M3 Junction 9 Improvement

Scheme Number: TR010055

8.8 Applicant Comments on Written Representations

17 July 2023

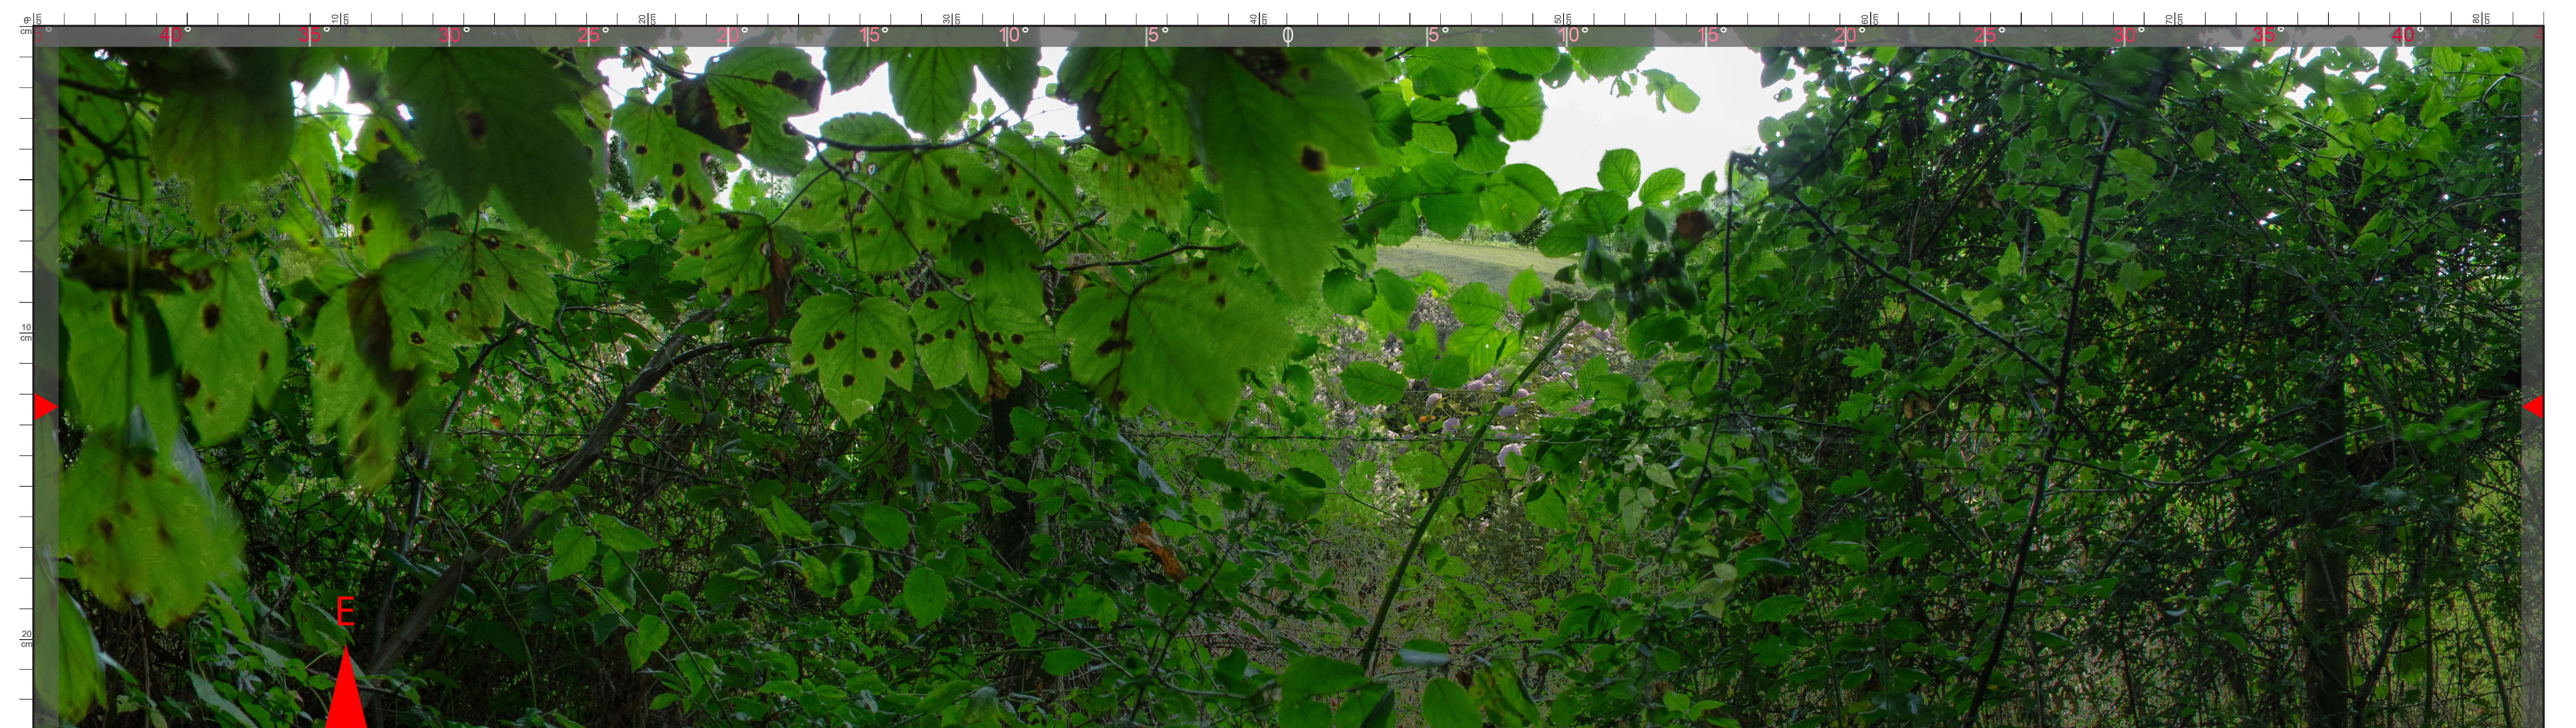
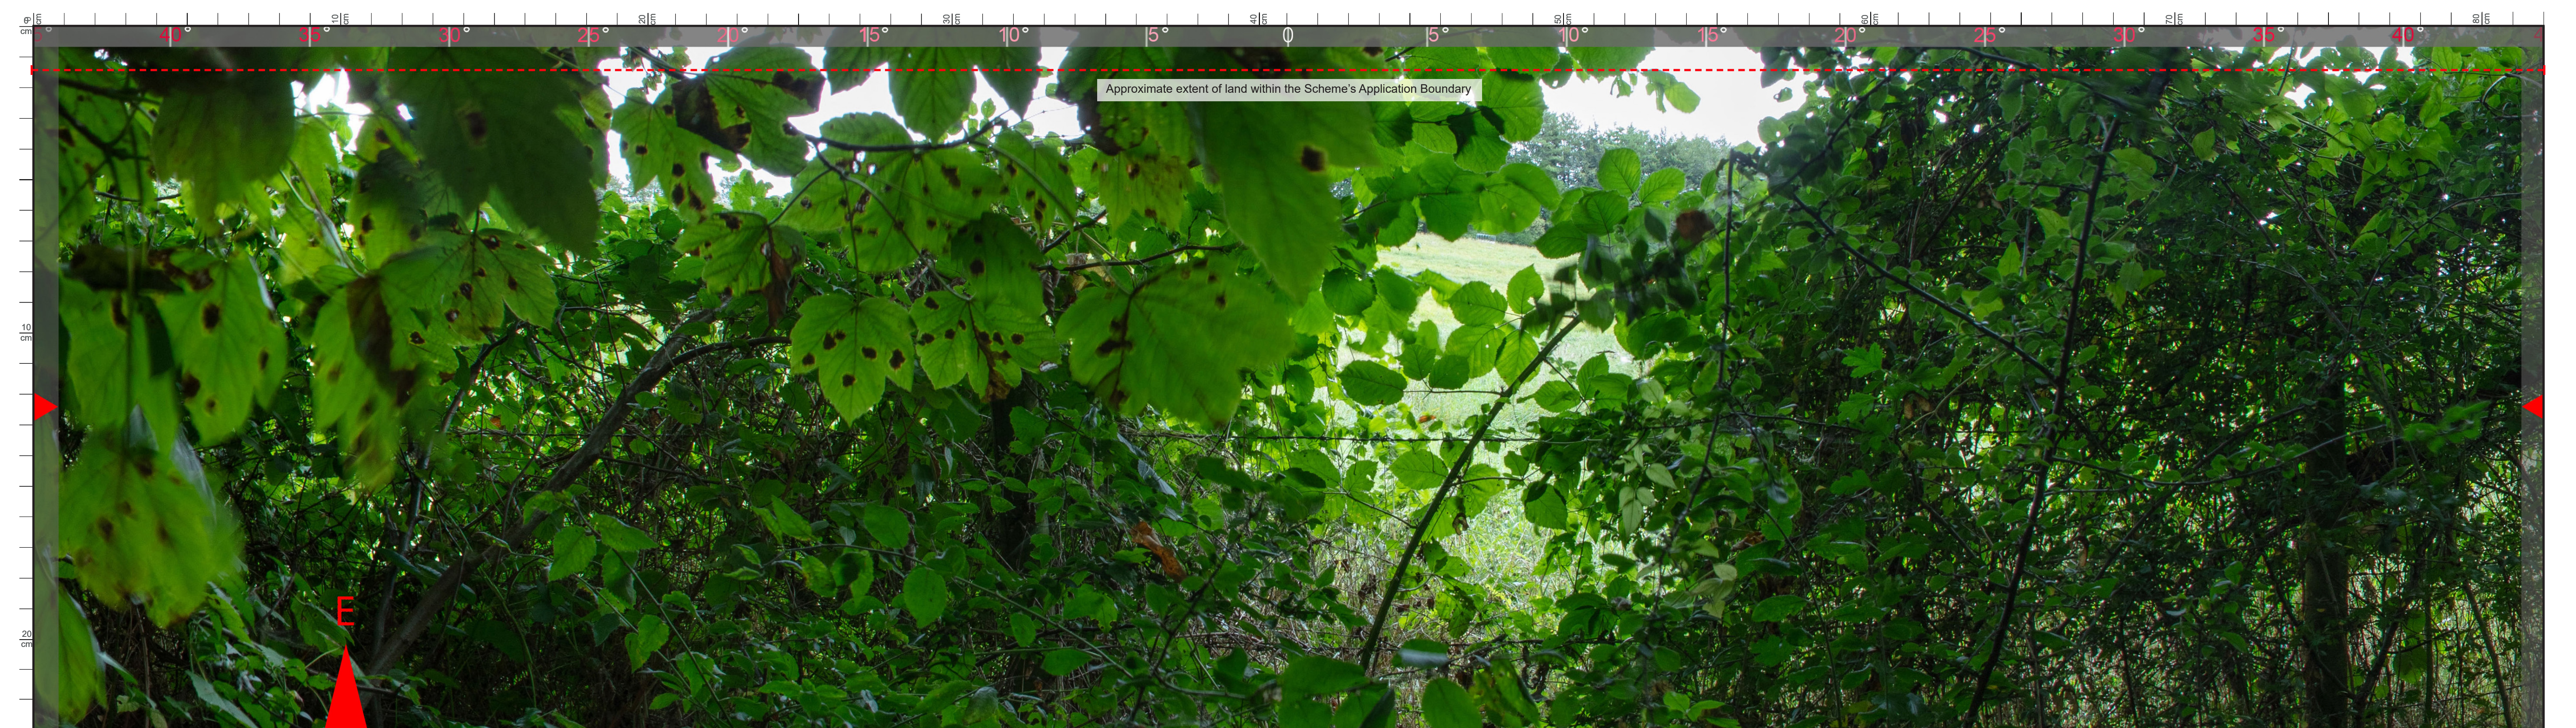
Reference	Written Representation	Applicant Comment
	<ul style="list-style-type: none"> ▪ Structures such as the attenuation ponds are not shown, and ▪ The road, particularly at Viewpoint 14, is not how it will actually look. There are no vehicles, no barriers, no road markings etc. <p>The Viewpoints need to be corrected to address the above and the applicant should provide confirmation that all the other viewpoints / visualisations are accurate.</p> <p>The SDNPA would also question how and in what way the overall design of the works has been 'landscape-led' (as required by the policies in the SDLP).</p> <p>A failure of the overall approach is the absence of specific design principles that conserve and enhance the landscape character or any recognition of this highly protected landscape within the overall scheme objectives (neither are reflected in the submitted Design and Access Statement, application document APP-162). For example, the SDNPA would have expected to see that the existing flowing Downland topography east of the M3 is conserved as much as possible thereby avoiding the erosion of the 18th – 19th Century planned enclosure landscape pattern and preventing further fragmentation of the Open Downs. In addition, the SDNPA would have expected to see proposals for filling of deposition material is designed in a manner which is sympathetic to this distinctive landform (again acknowledging the overall landscape character).</p>
